Forestry Corporation of NSW ABN 43 141 857 613
Western Region
Cnr Monash and Chelmsford Streets
Dubbo NSW 2830
(PO Box 865 Dubbo NSW 2830)
T: 0410 149 385
E: jarod.dashwood@fcnsw.com.au
www.forestrycorporation.com.au

RE: NARRABRI GAS PROJECT ENVIRONMENTAL IMPACT STATEMENT (SSD 6456) –
SUBMISSION FROM FORESTRY CORPORATION OF NSW

Forestry Corporation of NSW (FCNSW) has reviewed the Environmental Impact Statement for the Narrabri Gas Project as exhibited 21 February 2017.

Figure 2-1

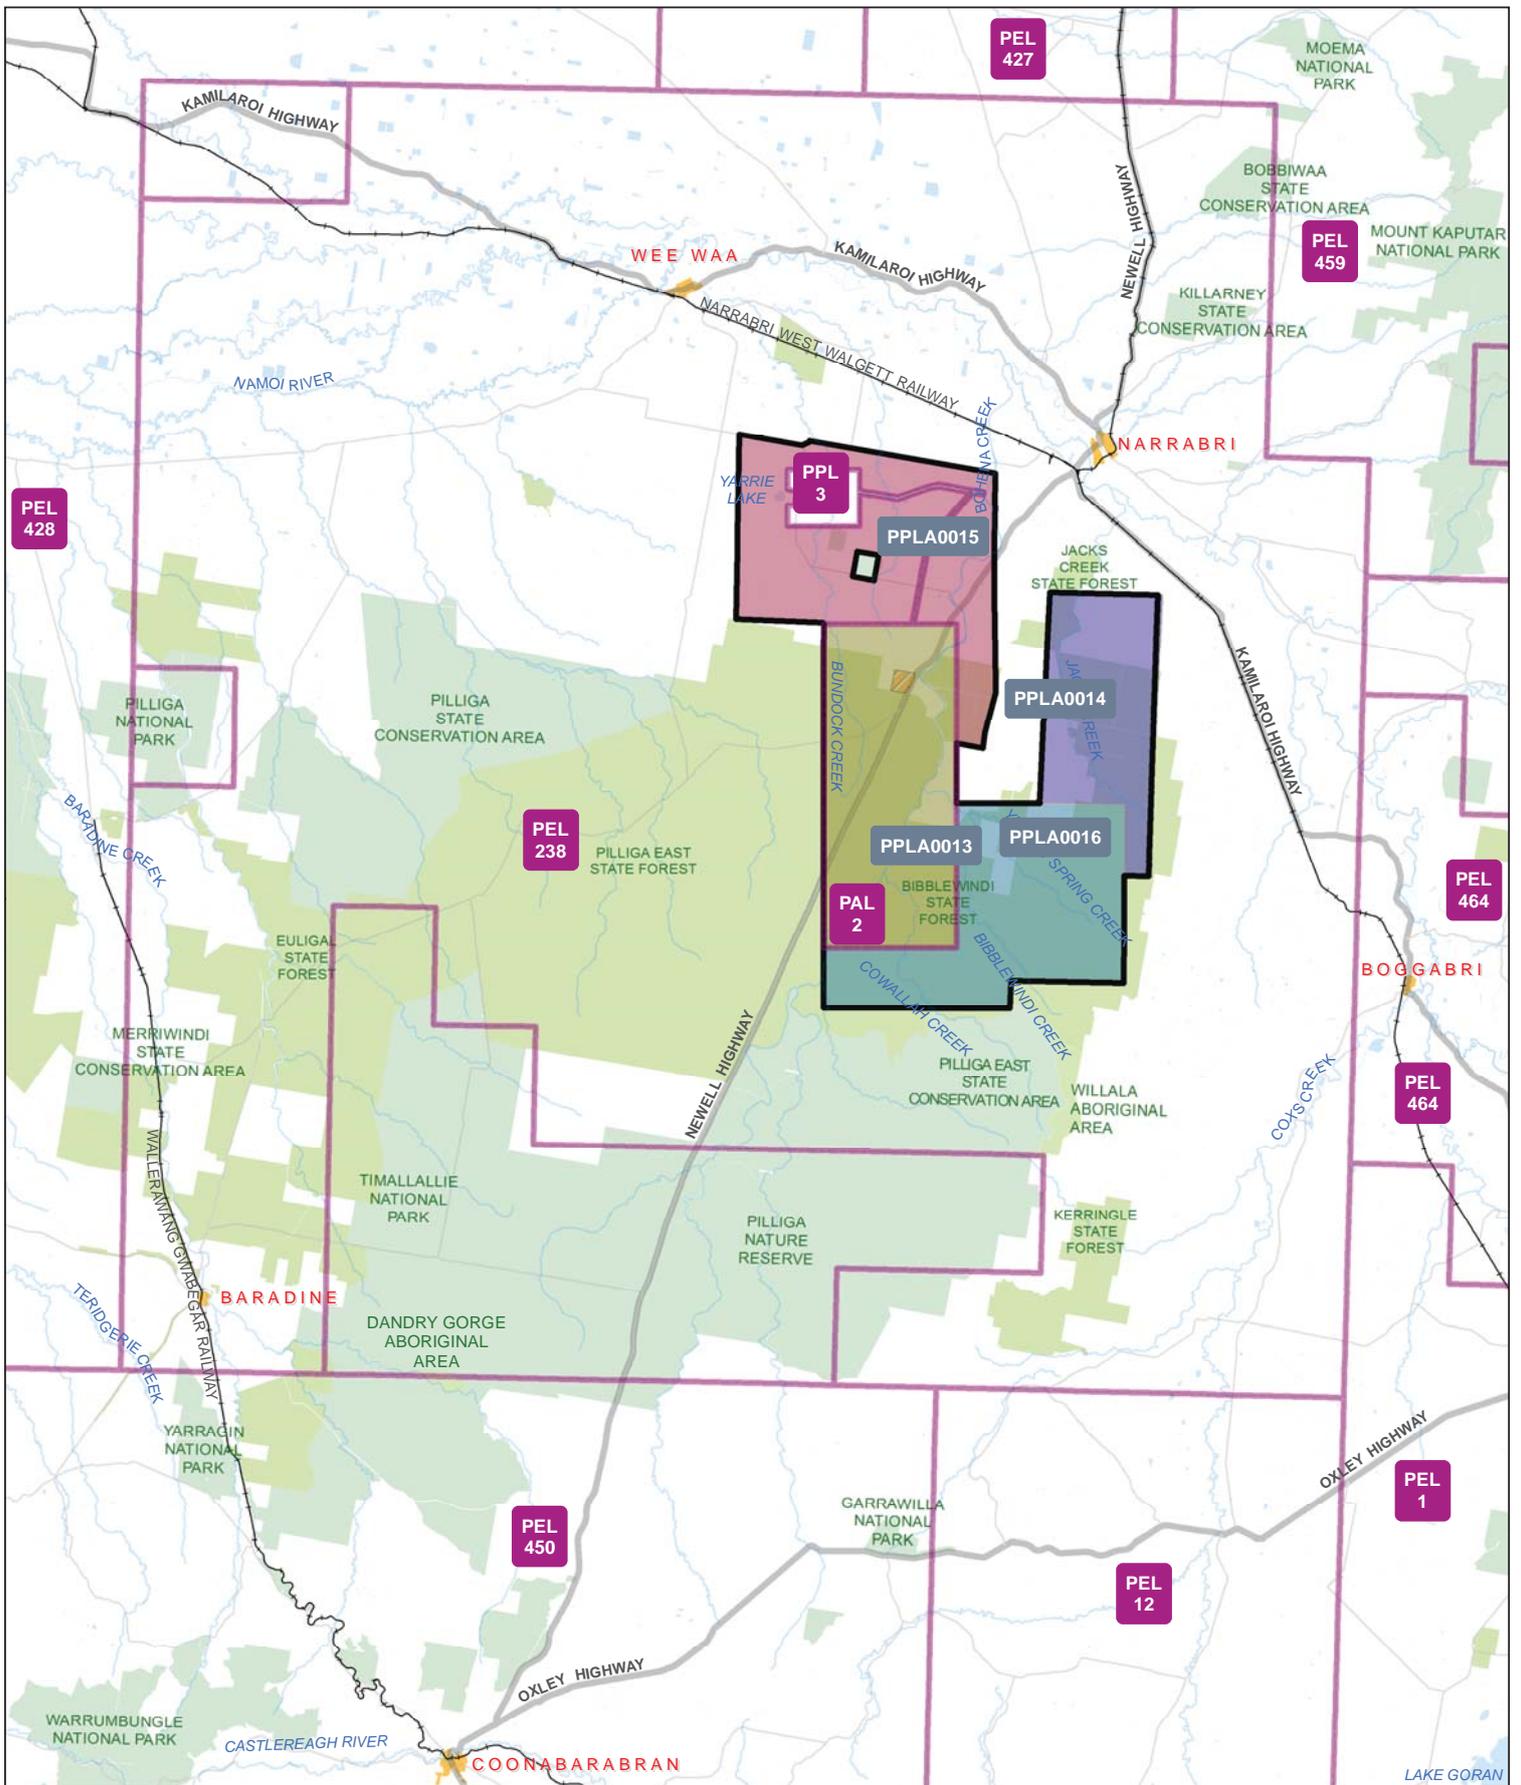
As described, an occupation permit was issued by FCNSW to allow access to Pilliga East State Forest and Bibblewindi State Forest (9-20). However the occupation permit does not extend authority to Jacks Creek State Forest as shown in the EIS in Figure 2-1.
